Ribble Valley Borough Council

Date: 10th April 2026

Address: 18 Accrington Road (Former Whalley Motor Services) Whalley BB7 9TD

Proposal: Proposed demolition of former motor services building and construction of new office building.

Drawing Title  
**Proposed Site Plan**

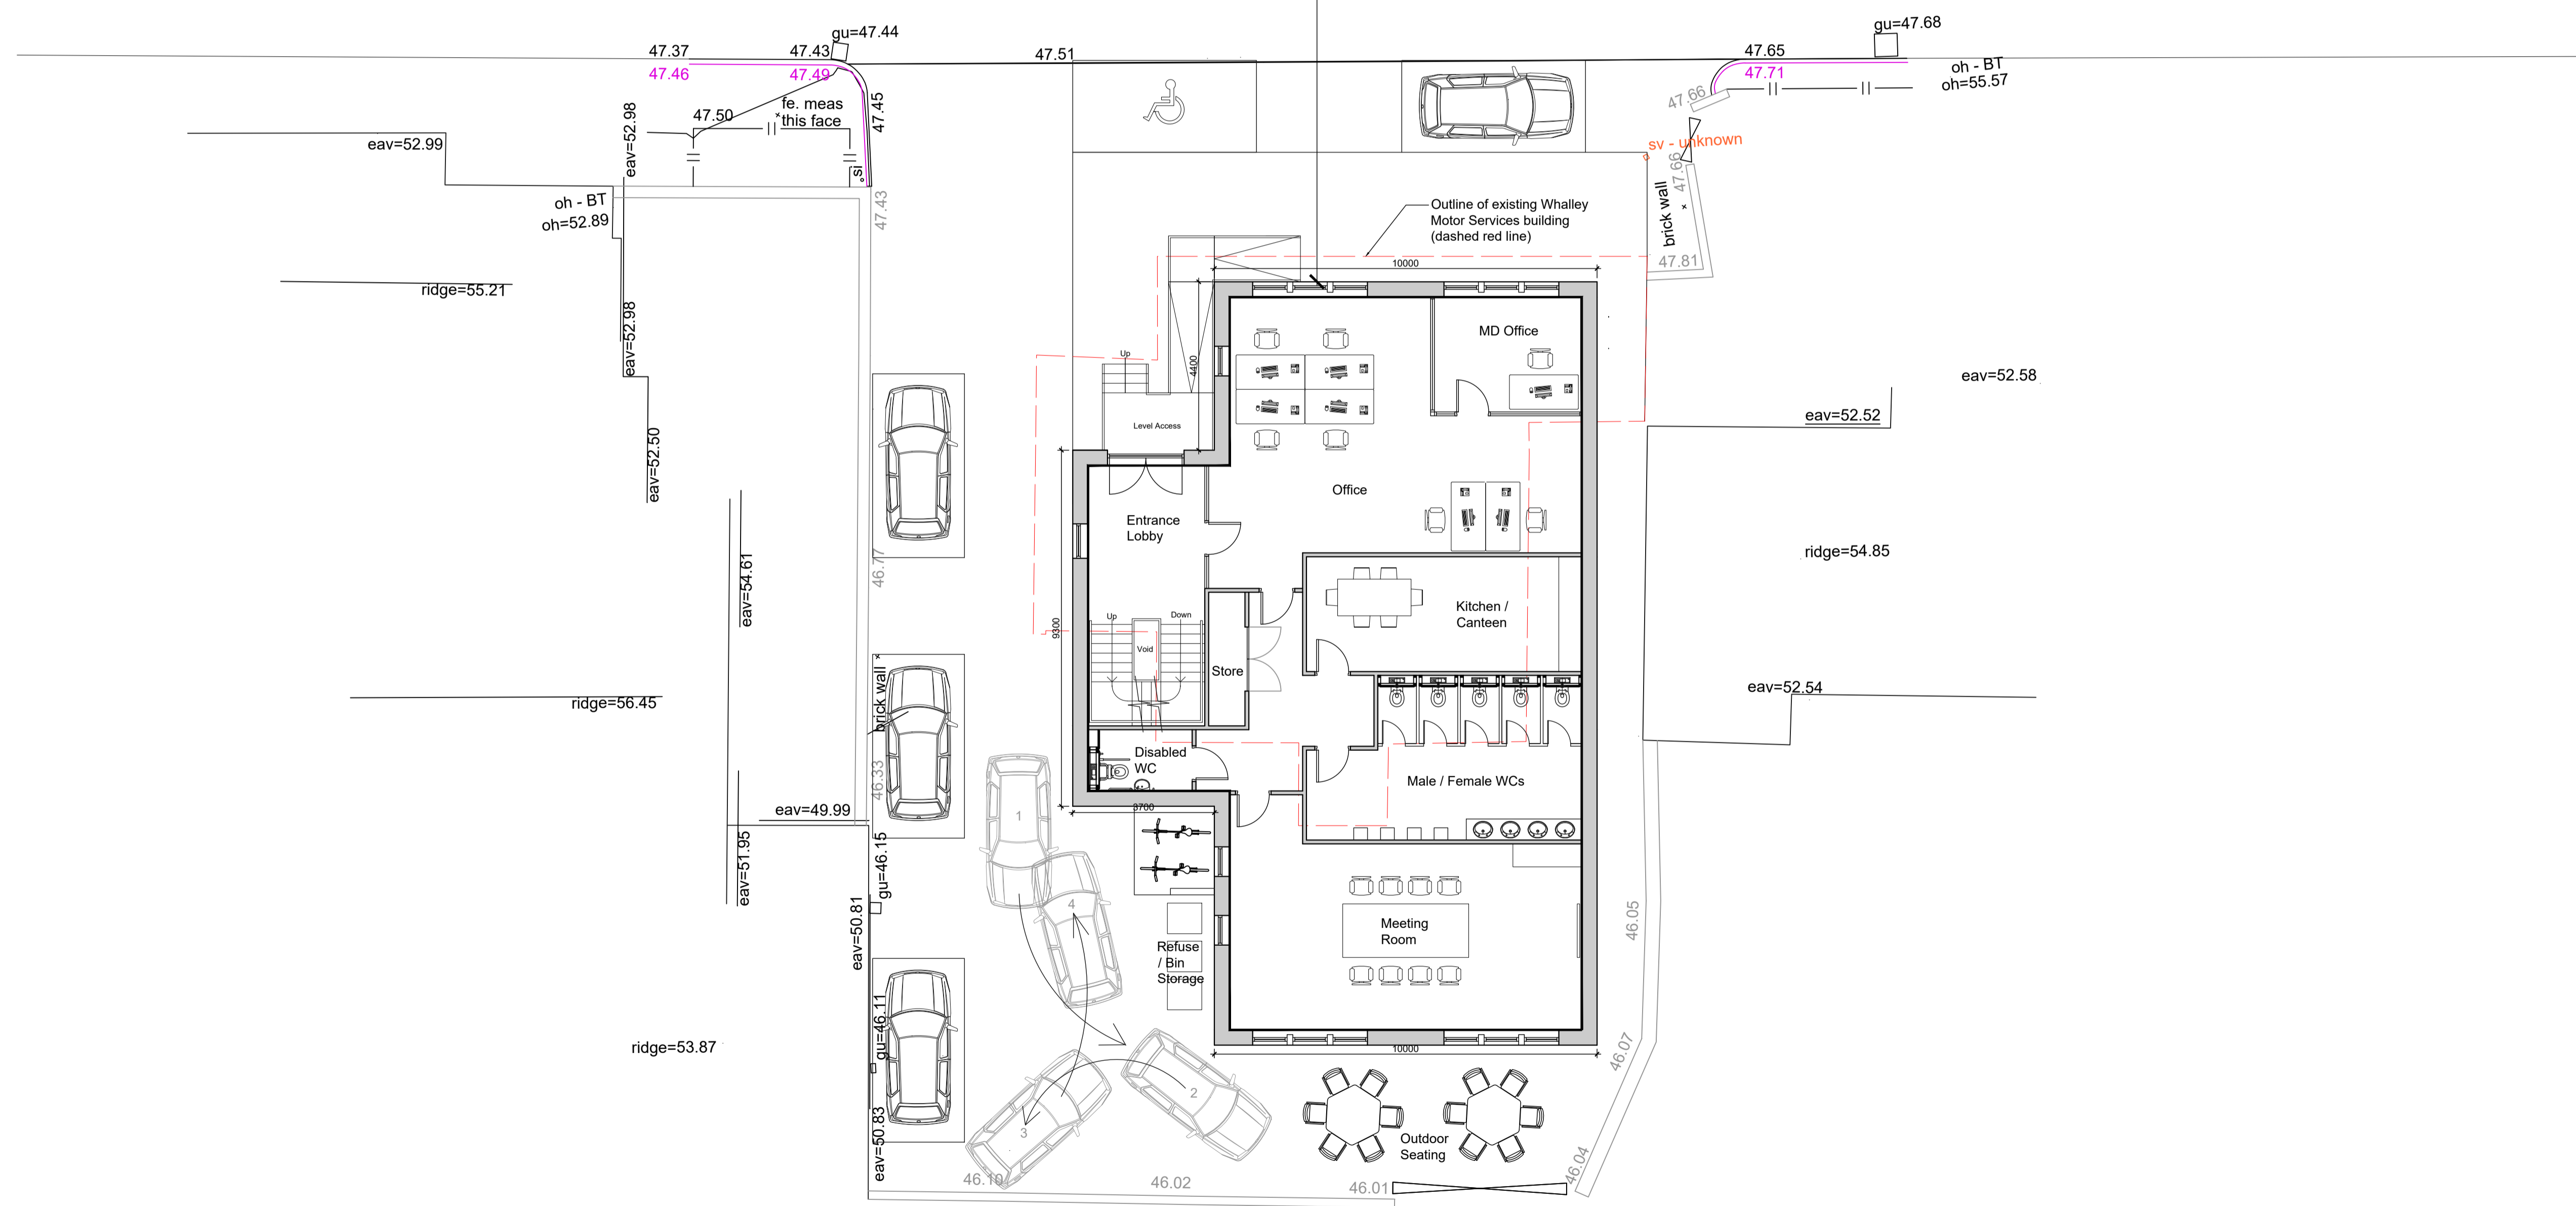
A new footway is considered necessary for this proposal, and we would request that the plans are amended to reflect this. The alterations to the highway will be required to be completed under a S278 agreement with Lancashire County Council.

We would request that the site plan is amended to provide 5 spaces along the western boundary and 1 space where the outdoor seating area is currently proposed. This will provide 6 off-street parking spaces, plus 2 covered and secure bicycle spaces.

The 2 spaces proposed to the front elevation would need to be removed to accommodate the new footway.

Lancashire County Council acting as the Highway Authority would request that the footway to the Accrington Road elevation is added to the layout and the 2 spaces are removed and that the amount of car parking is increased on site as detailed above.

- a. A new 2m wide footway along the full frontage of the site on Accrington Road constructed to Lancashire County Council specification to tie into works conditioned at the adjacent site approved under reference 3/2022/1158.
